April 13, 2017

**RE: Response to Comments
Level I Minor Residential Application
44 Quebec Street
Portland, Maine**

We have reviewed your comments specific to the Site Plan Requirements provided on March 28, 2017 for the Level I Minor Residential Application. Please find our responses to the comments below in *italics*.

SHEET TITLE
Existing Conditions and Removals Plan

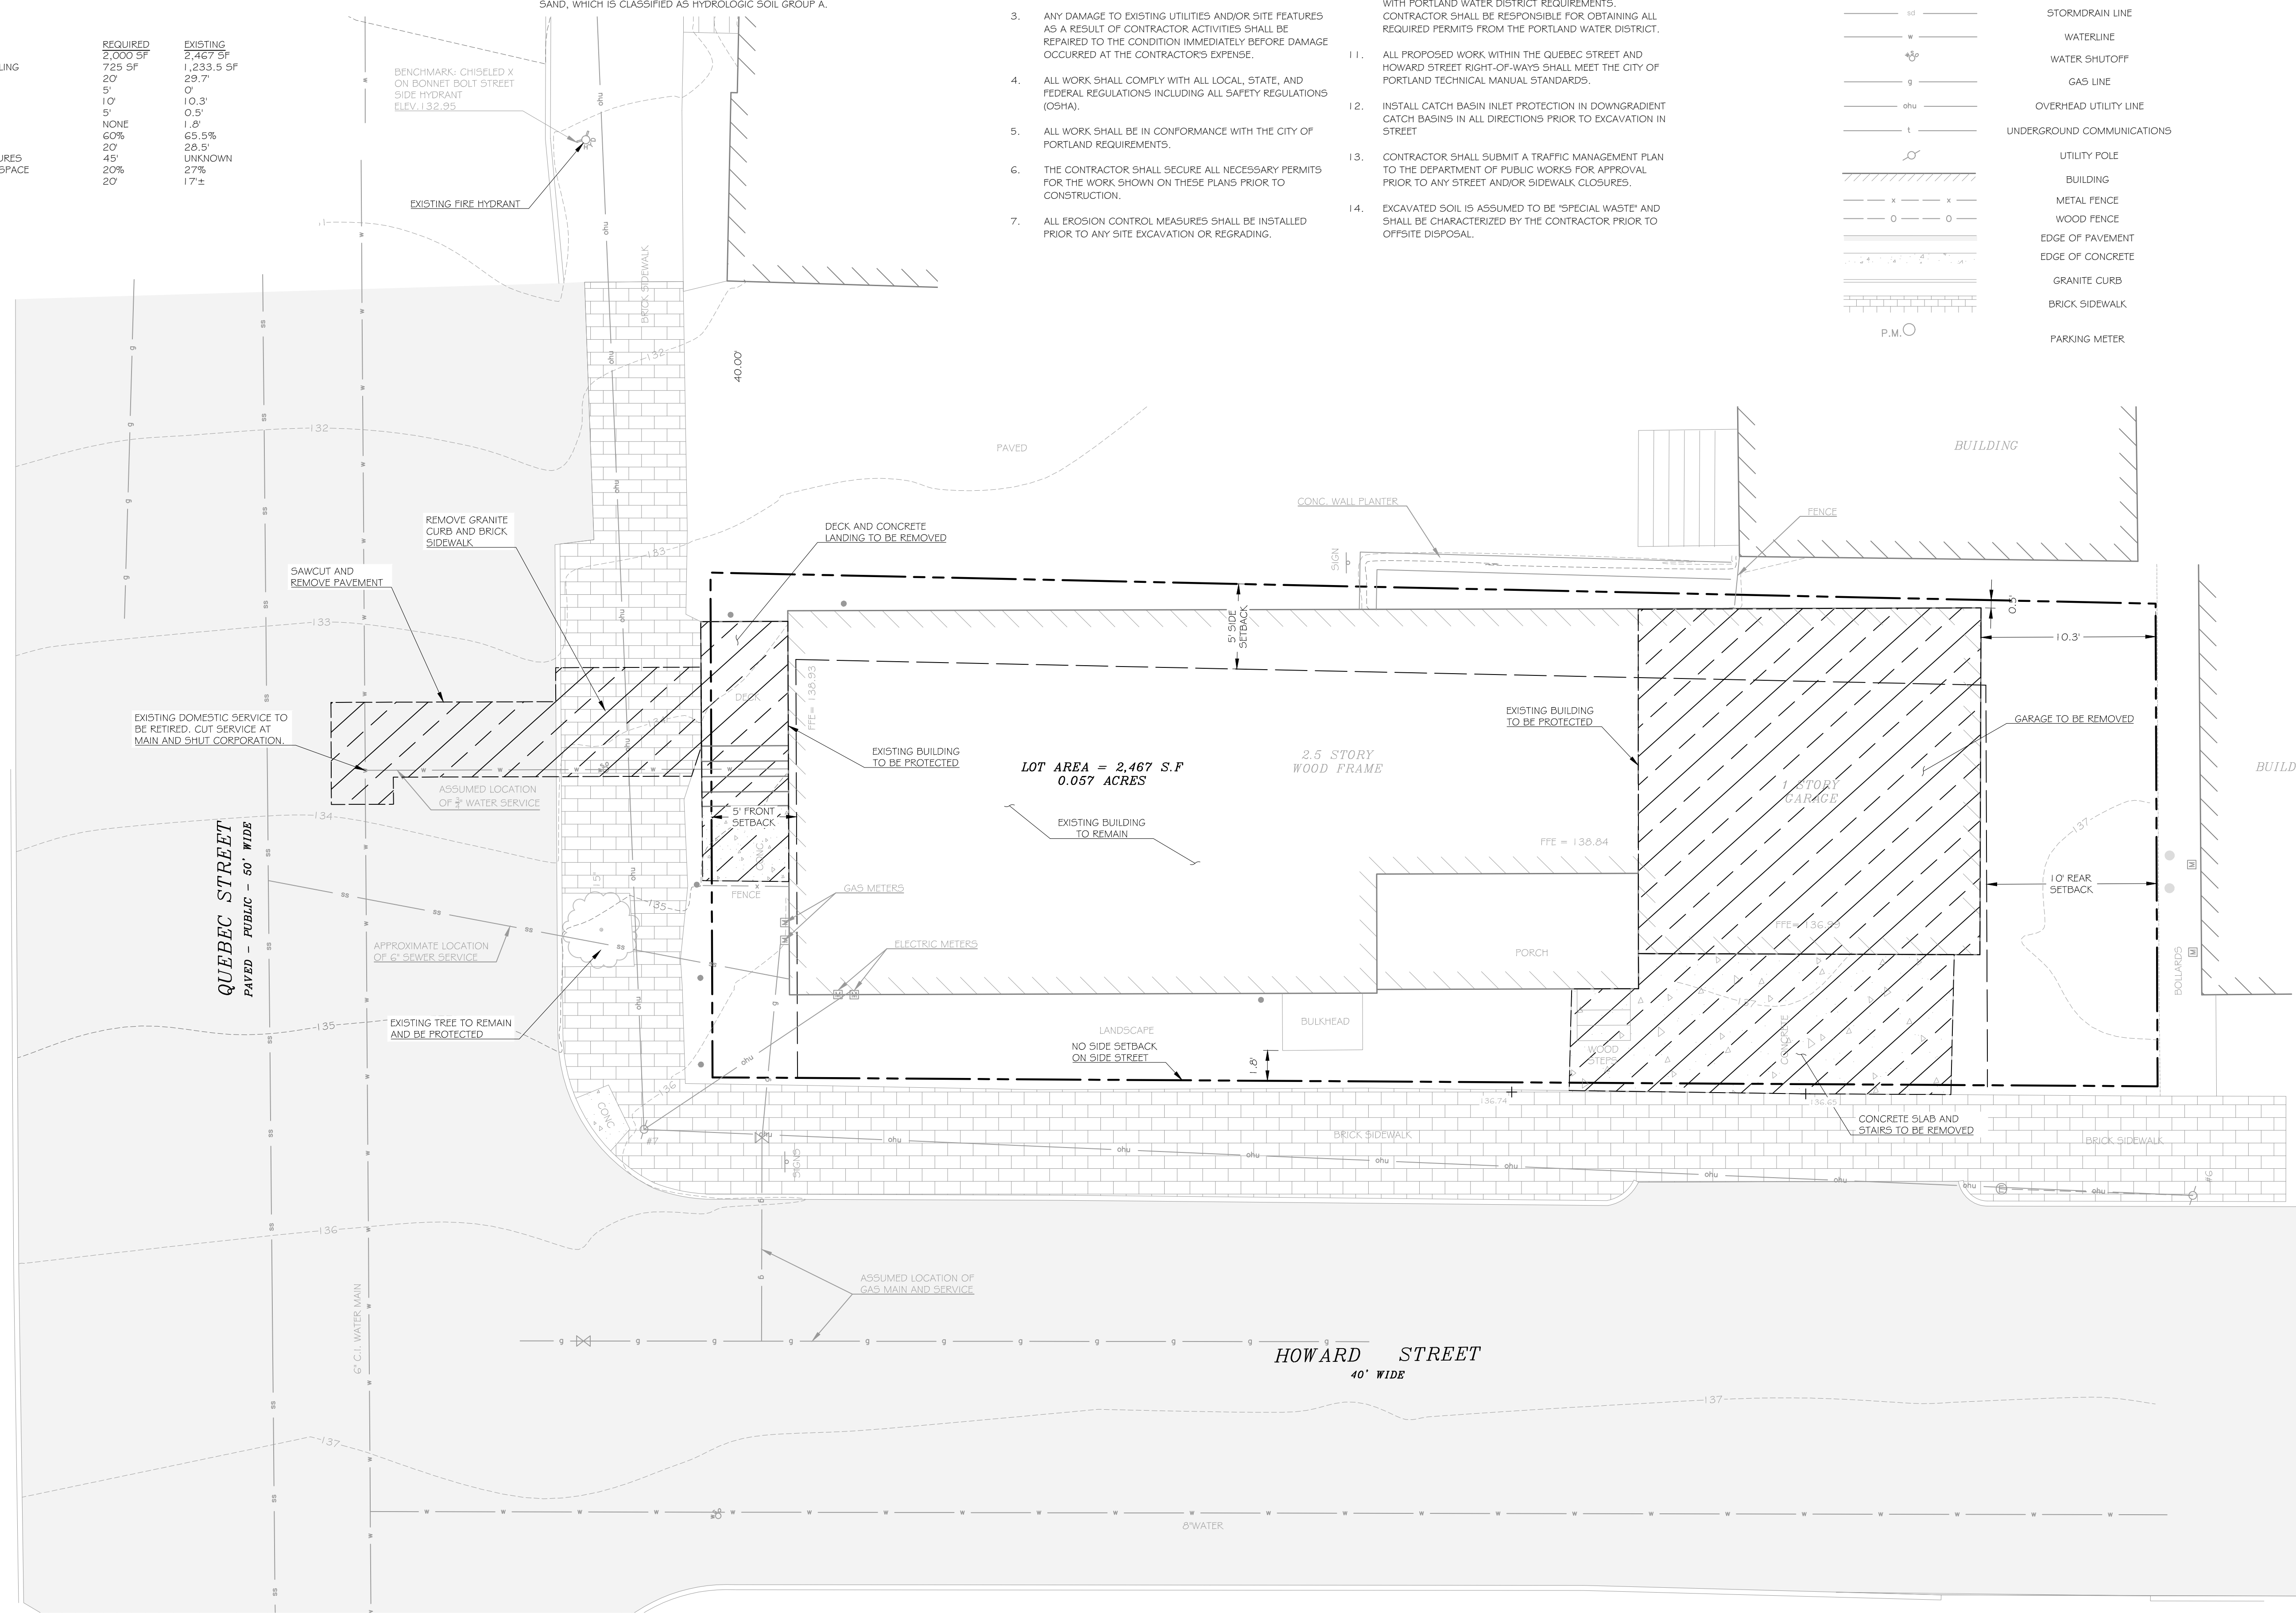
- b. Soil type at the property.

Based on the USDA online websoil survey, onsite soils are Hinckley loamy sand, classified as hydrologic soil group A. Plan reference 1.4 has been added to the plans indicating the soil type. A copy of the soil map is enclosed.

DRAWN BY SWC
SHEET TITLE Site Layout and Utilities Plan

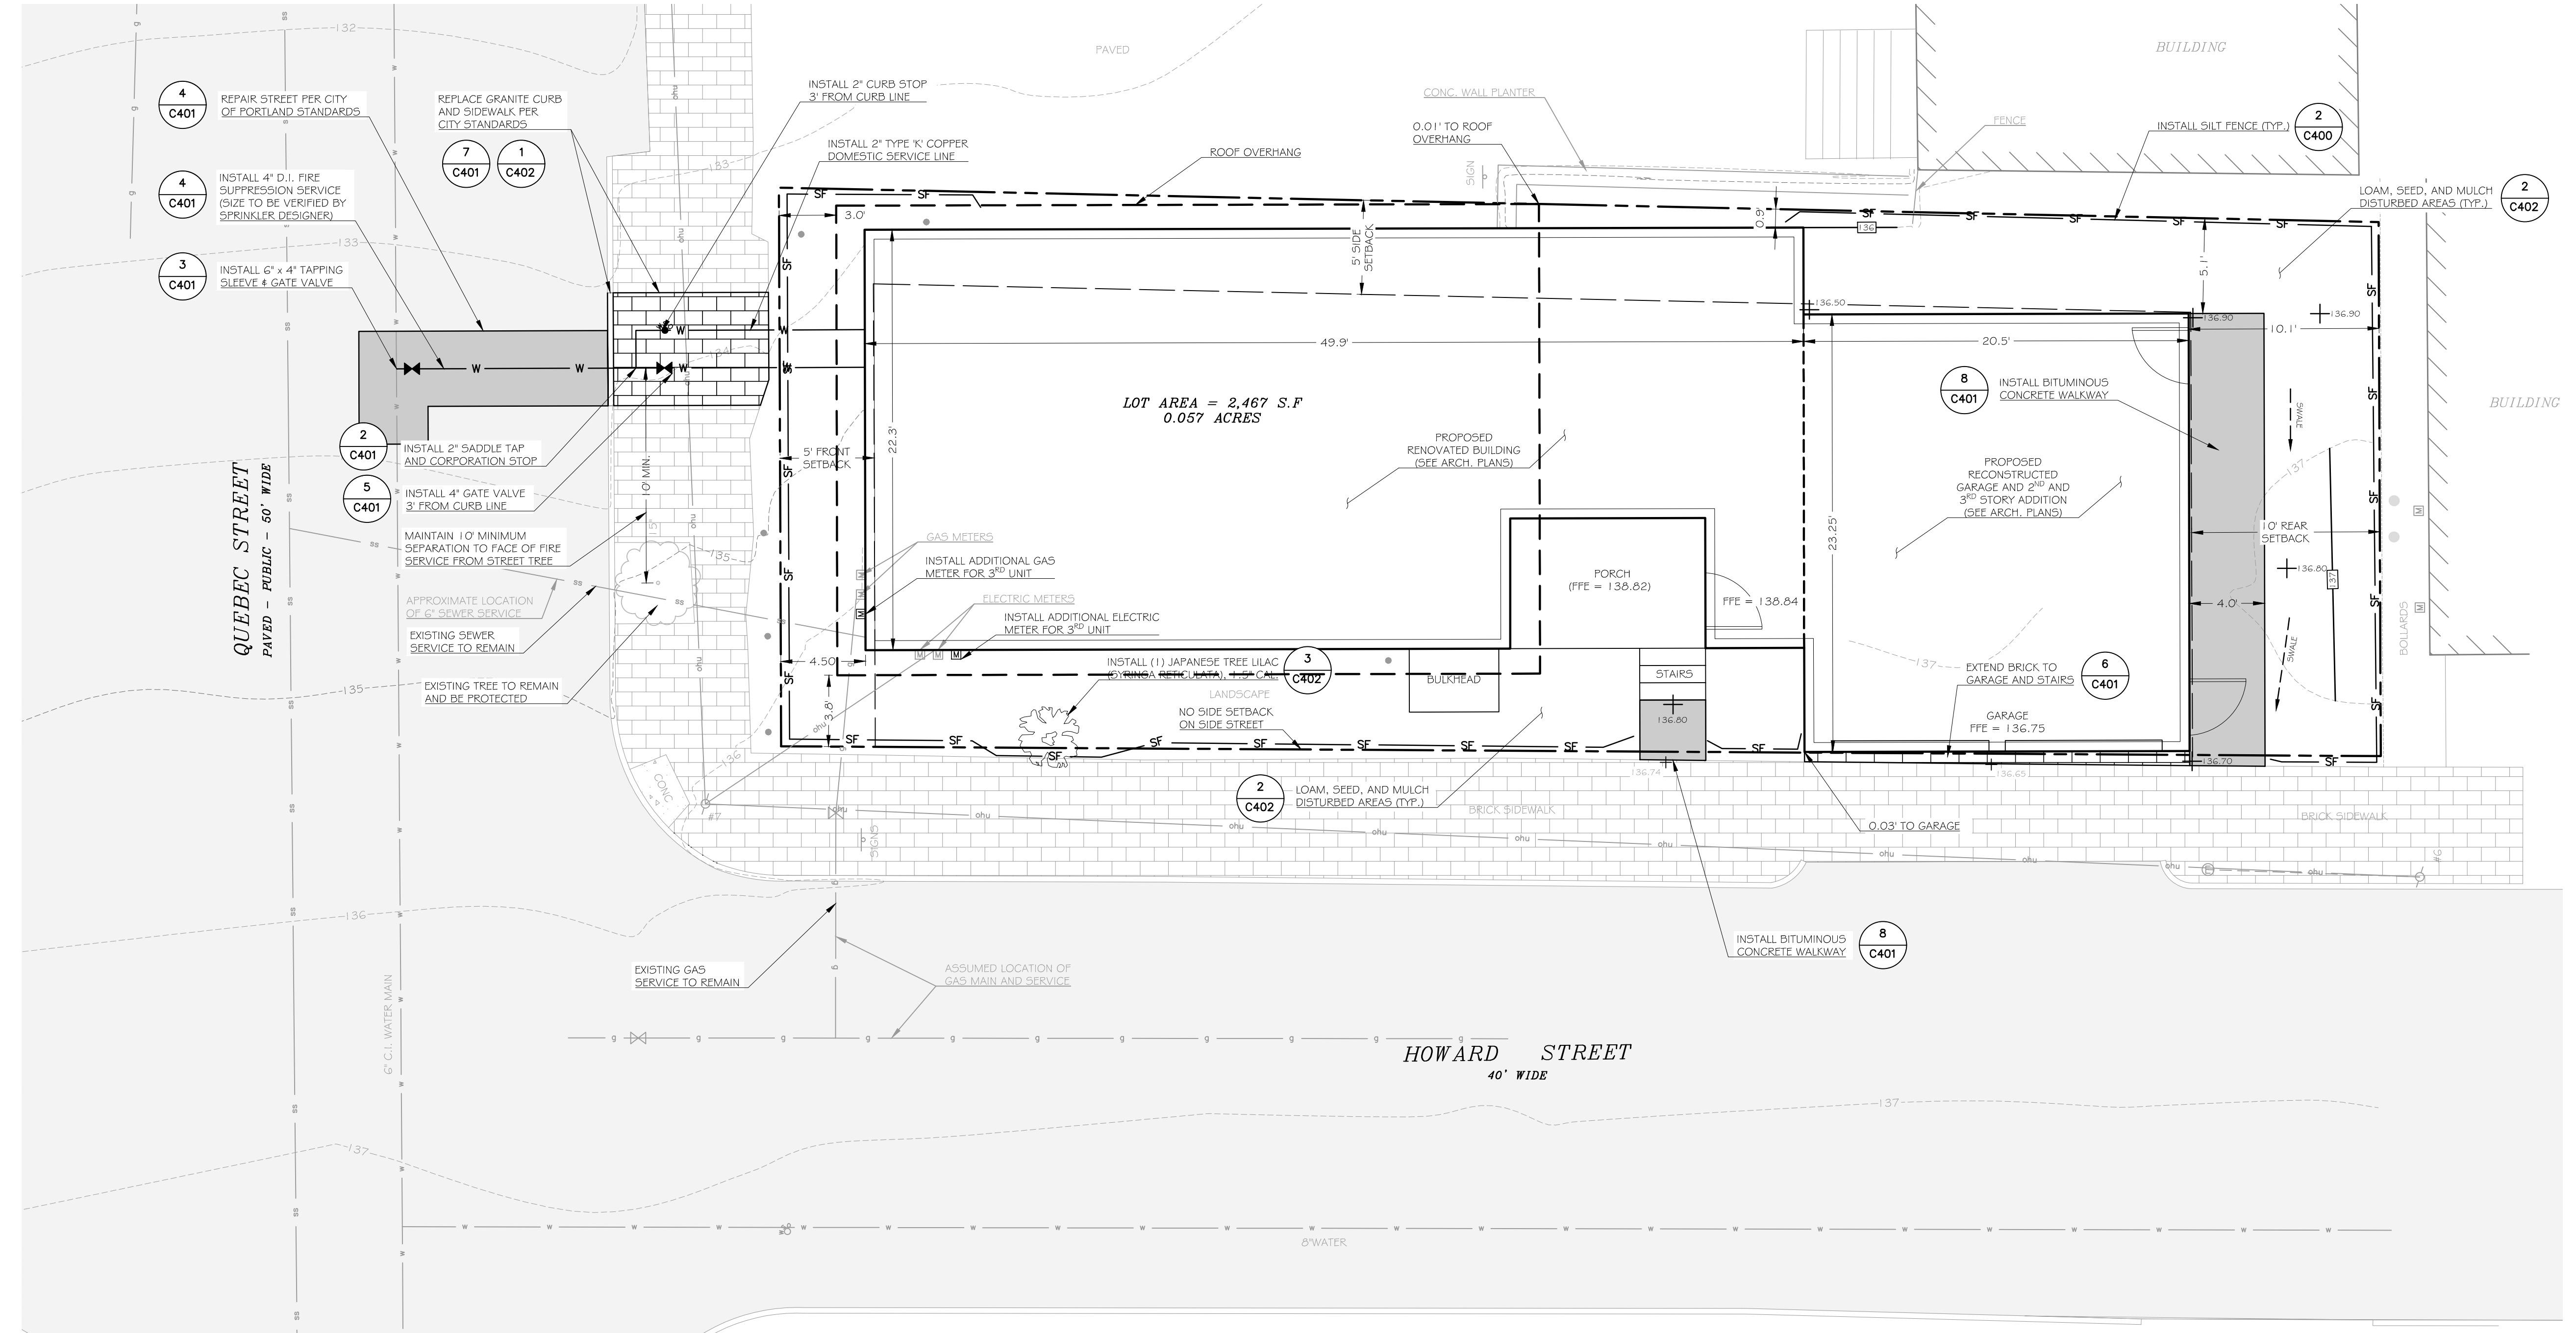
- a. Existing and proposed structures, as applicable, and the distances from all property lines. **Please clarify whether any overhangs extend over City right-of-ways.**

Dimensions to the building face and overhangs are shown on the enclosed drawings. The architect has reported that no projections, cornices, or roof overhangs will extend into the City right-of-way.

- f. Please add to the site plan, the required 2 street trees along the street frontage meeting the City's minimum arboricultural standards, or clarify and describe existing trees that are to be saved.

As discussed on the phone, the 1 existing street tree, which is a significant mature tree will remain. One street tree is proposed on the site plan along Howard Street. See section b)2.b.iii.b. in the previously submitted zoning compliance assessment for explanation of the location of this tree.

Upon further discussion, the City has requested a 3rd tree to meet the zoning standard. Given the site constraints, the Applicant is respectfully requesting a waiver from installation of the 3rd tree. The only location to install the 3rd tree would be in front of the windows along Howard Street. This location would significantly reduce the available light into these windows and may also cause a maintenance problem and safety hazard given the limited space between the tree and windows. The Applicant is willing to pay into the City's tree fund for the 3rd tree.
